**From:** Contact Centre (CRM) <contact@ribblevalley.gov.uk>  
**Sent:** 21 May 2022 12:26  
**To:** Planning  
**Subject:** Planning Application Comments - 3/2022/0421

**Planning Application Reference No.:** 3/2022/0421

**Address of Development:** 21 Paris  
Ramsgreave  
BB1 9BJ

PROPOSED NORTH EAST ELEVATION (FRONT). SCALE 1:100

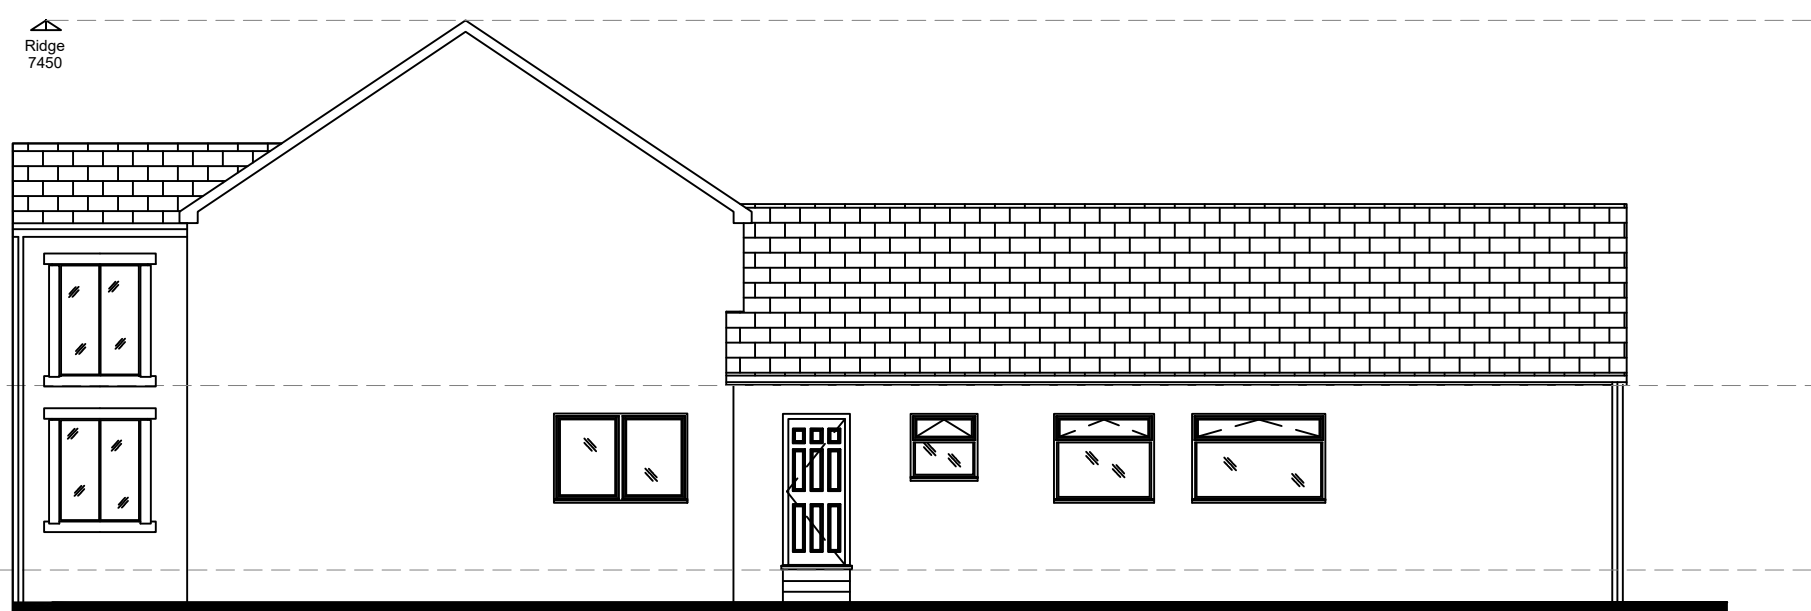
**Comments:** I wish to object to the revised planning application for the above property on the grounds that a 2 storey porch is not in keeping with the surrounding properties. A previous variation to the original plan was passed, supporting the assertion that the neighbours wished the building to be more in character with the other properties. If this next variation is passed, it will be a contradiction of that reasoning. The two storey porch is an incongruous feature which will detract from the character of the area, and result in a harmful impact on the visual amenities of the surrounding area.

Rooflights will facilitate the creation of more bedrooms, substantially changing the character of the original three bedroomed house, which according to the current plans is now a five bedroomed house.
